**From:** Contact Centre (CRM) <contact@ribblevalley.gov.uk>  
**Sent:** 04 July 2025 15:37  
**To:** Planning  
**Subject:** Planning Application Comments - 3/2025/0133 FS-Case-728633379

**Planning Application Reference No.:** 3/2025/0133

**Address of Development:** Loft Shay , Knowle Green , Longridge

Consultation response to Planning Application 3/2025/0133: Change of use of land to form extension to residential curtilage. Proposed detached garage to include solar panels and living accommodation above. Insertion of second floor side facing window to main dwelling.  
Applicant address: Loft Shay Farm, Knowle Green, Nr. Longridge, Preston PR3 2YQ

PROJECT
Proposed Detached Garage & Associated alterations
SHEET
Proposed Site Plan Revision D

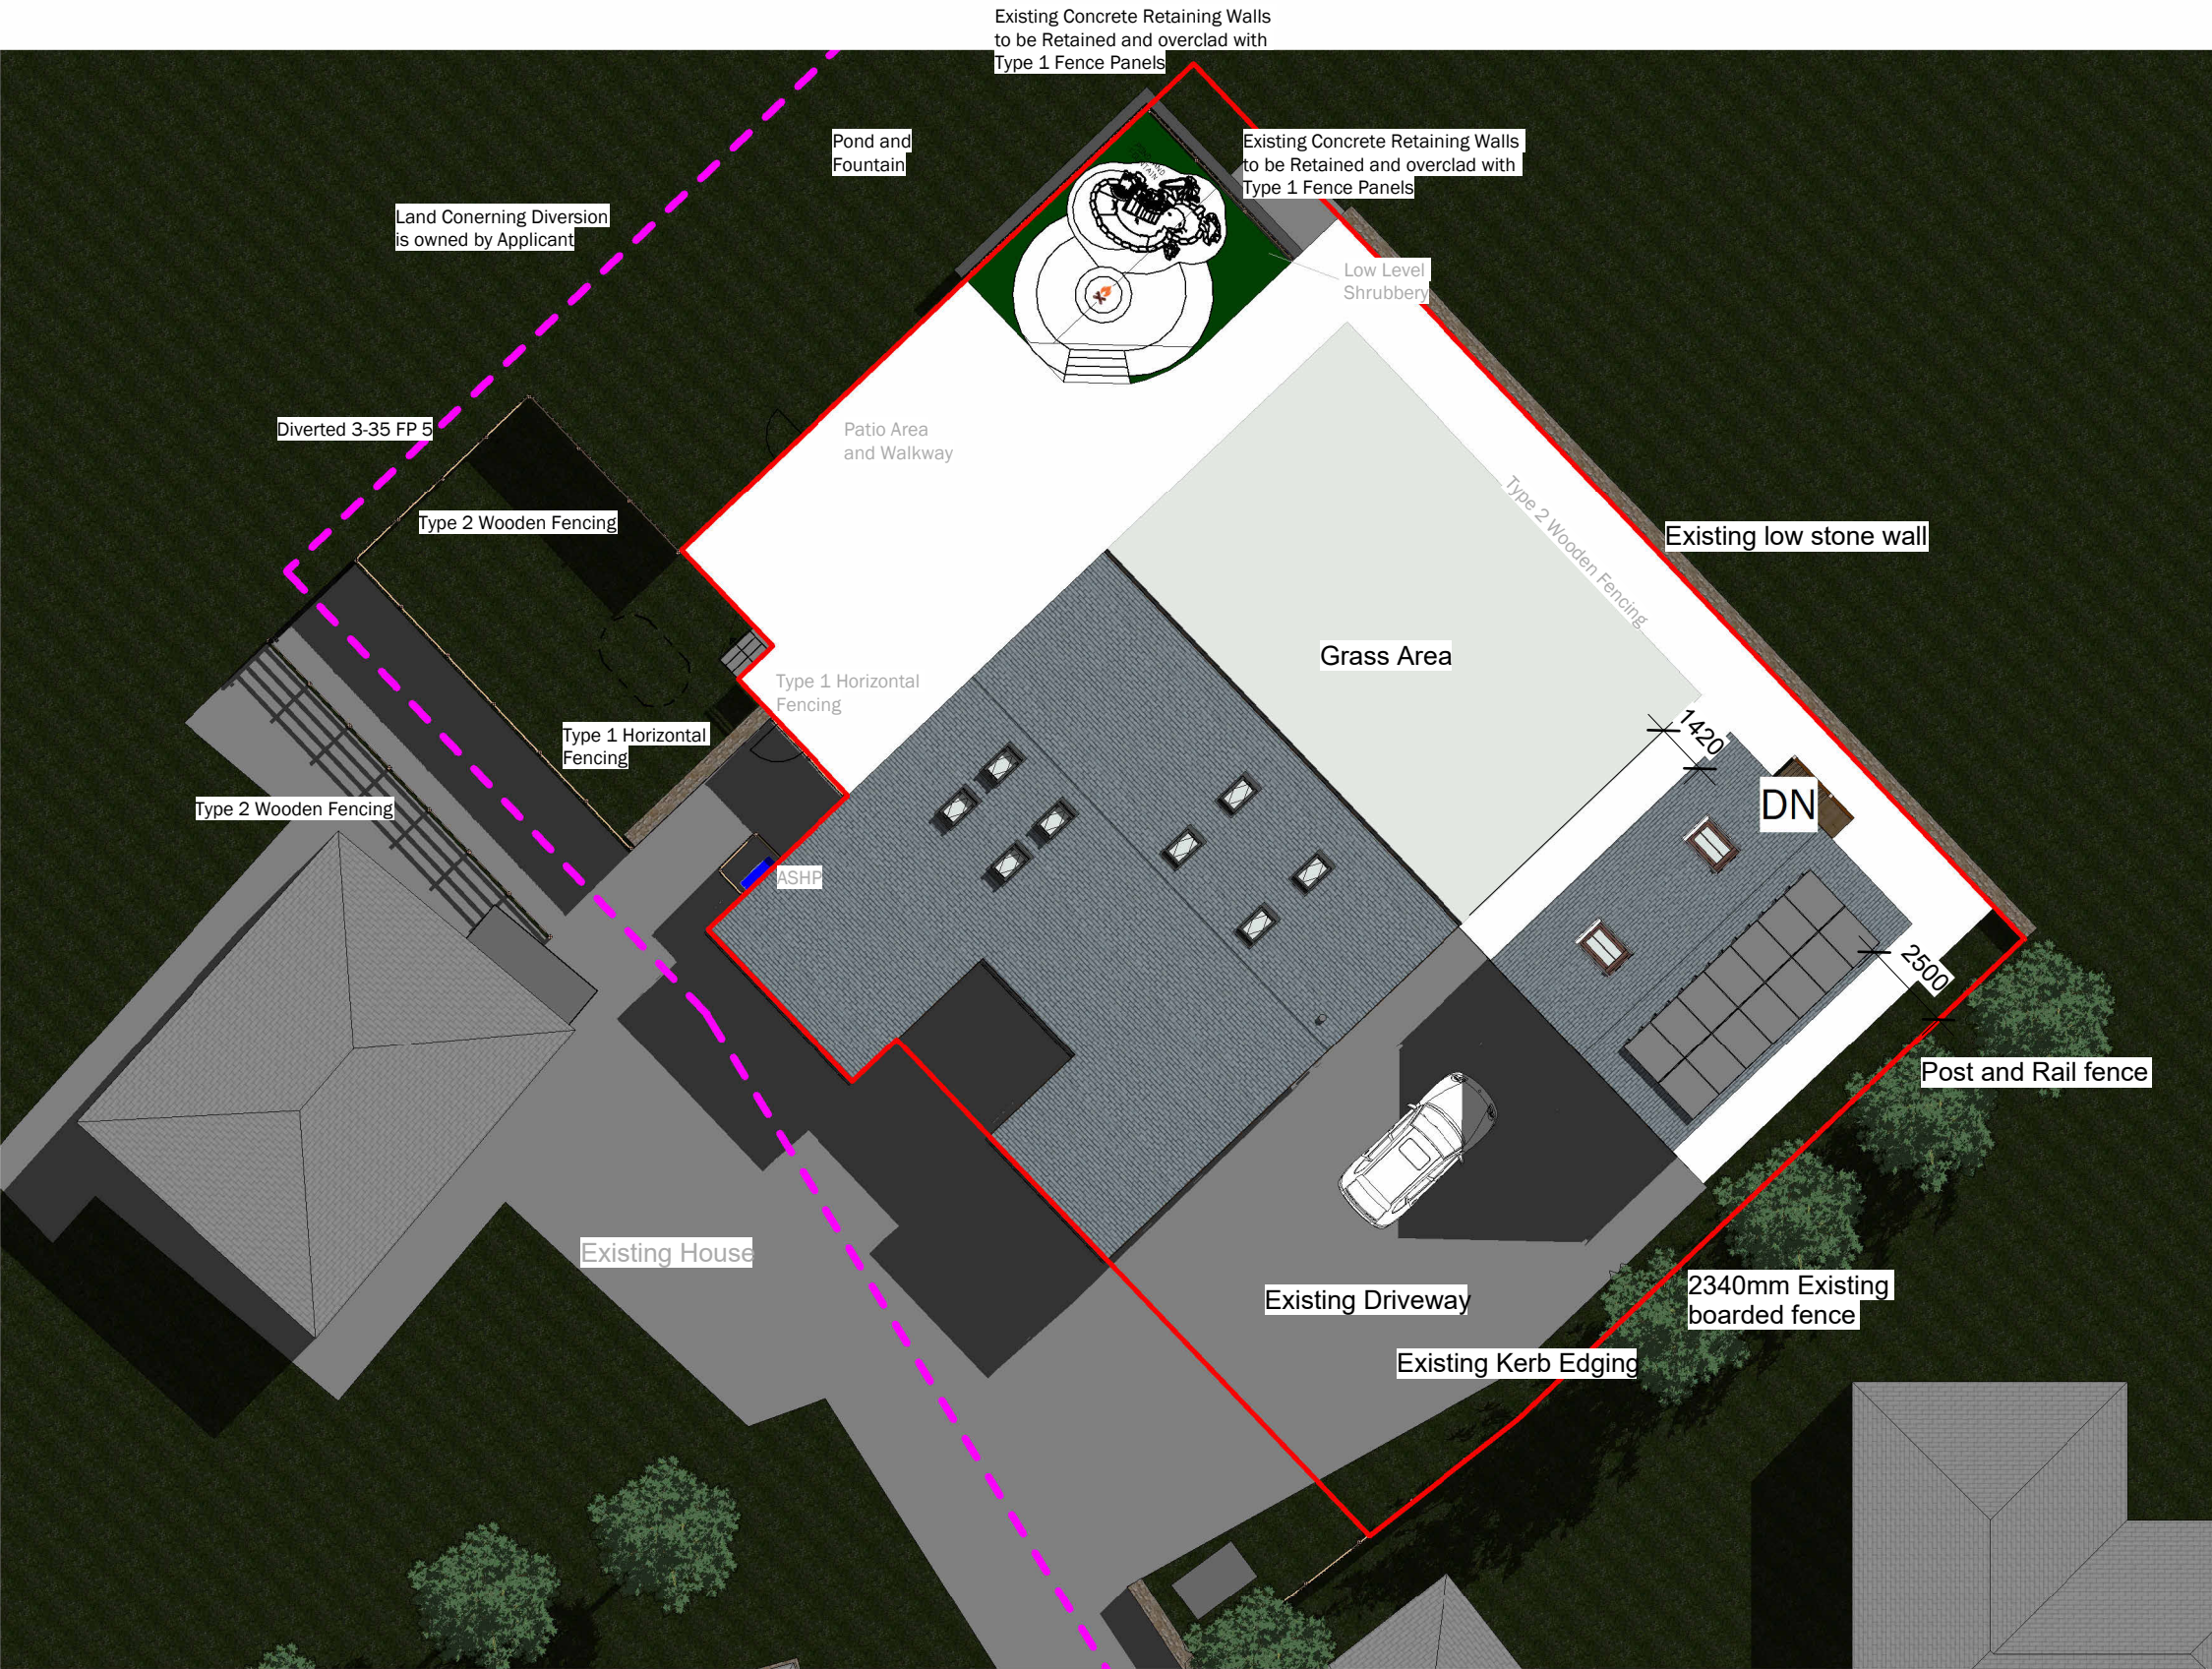
In addition to the above, the fact that the proposed building would be situated apart and set back from the main dwelling, towards the outer corner of the site, exacerbates its adverse visual impact, blocking natural landscape views that were previously and currently available for all.

It could be built next to the barn, and not at the outer limits of the space. This proposed building does not fit the description 'ancillary' but rather the description 'a new extension or outbuilding' , which were precluded in the permission granted for the barn conversion of 2021
